Historic Environment

Planning Consultation Comments - DRAFT

RE: 19/00522/NSIP Proposal Site: Potential Aquind Interconnector Site, Old Mill Lane, Lovedean, Denmead

TITLE: Application document reference 2.7
Indicative Converter Station Area Layout Plans
Sheet 1 of 3

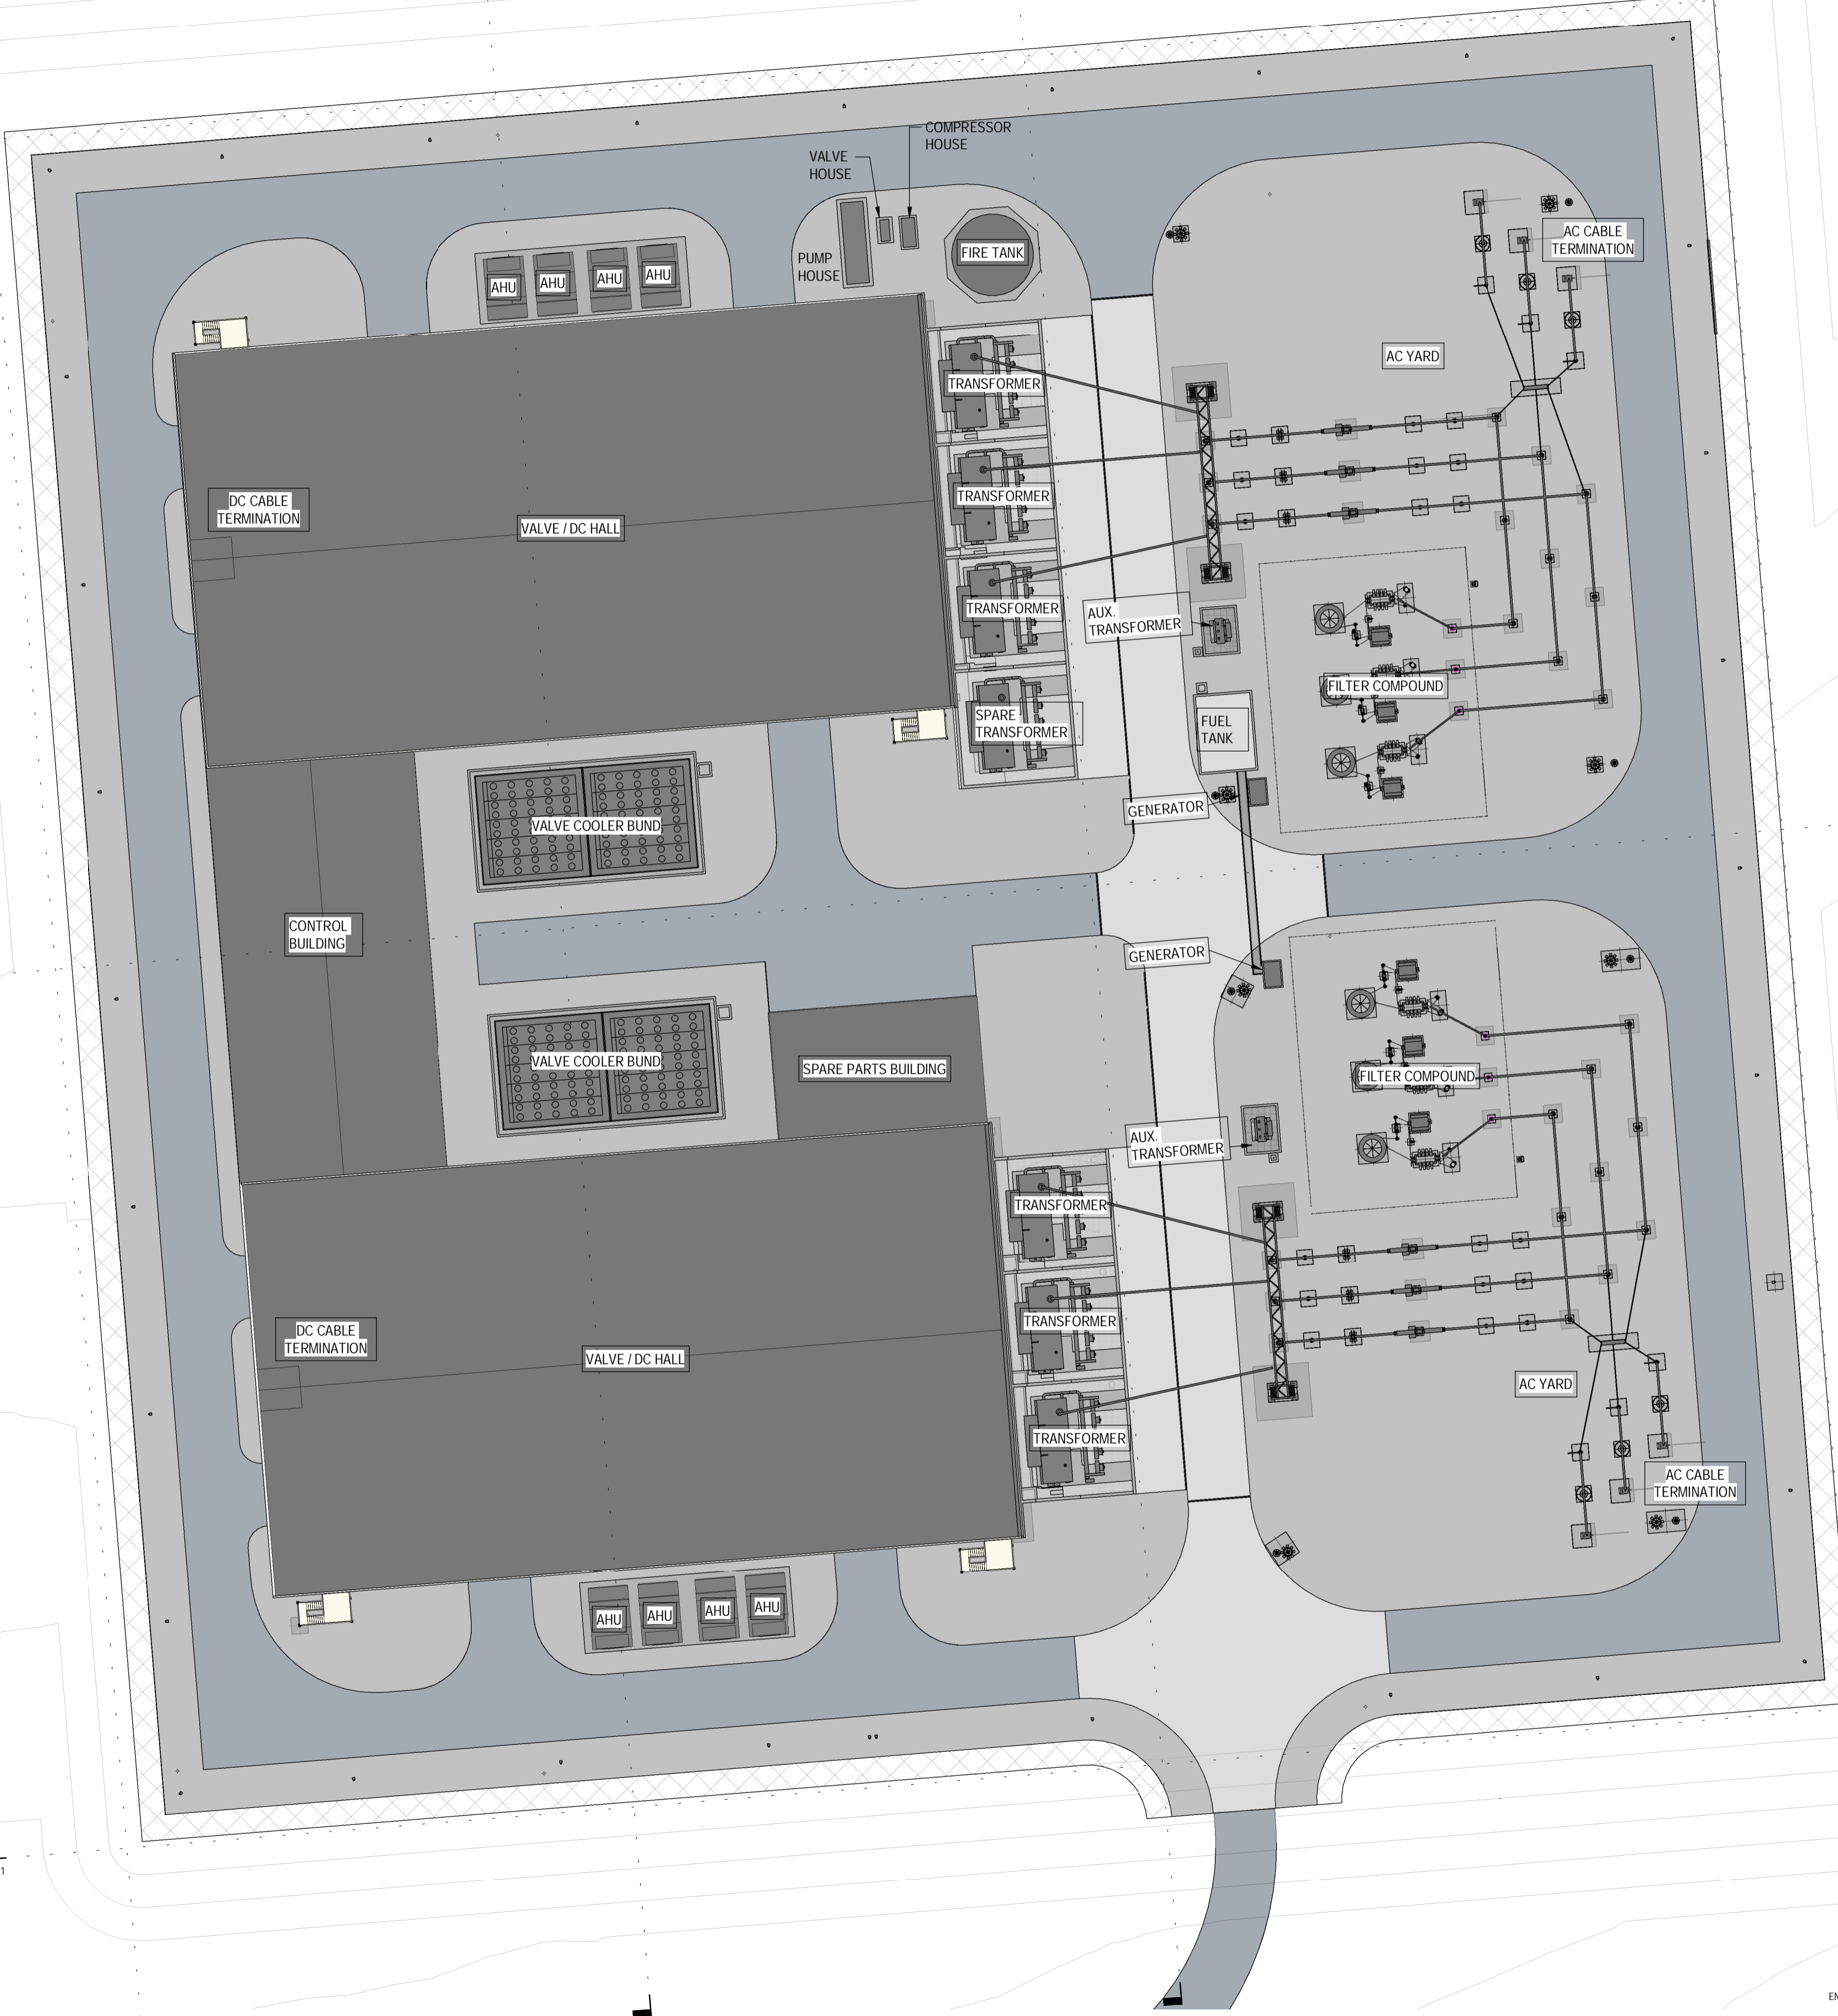
- It is unclear why there is a need for the large volumes of open space above the equipment as depicted in the submitted cross sections. It is assumed that there are sound operational requirements for this space but this is not explained in the submission and therefore raises the questions as to whether there is scope to significantly reduce the height and scale of the buildings.

The submitted elevations are all indicative and heavily caveated as such. There is therefore a need to control the final appearance of the converter station and its materials by condition. Similarly there are no details of the potential vehicular access, one of which would be in close proximity to the grade II listed barn at Shafter's Farm, and these would also need to be adequately controlled.
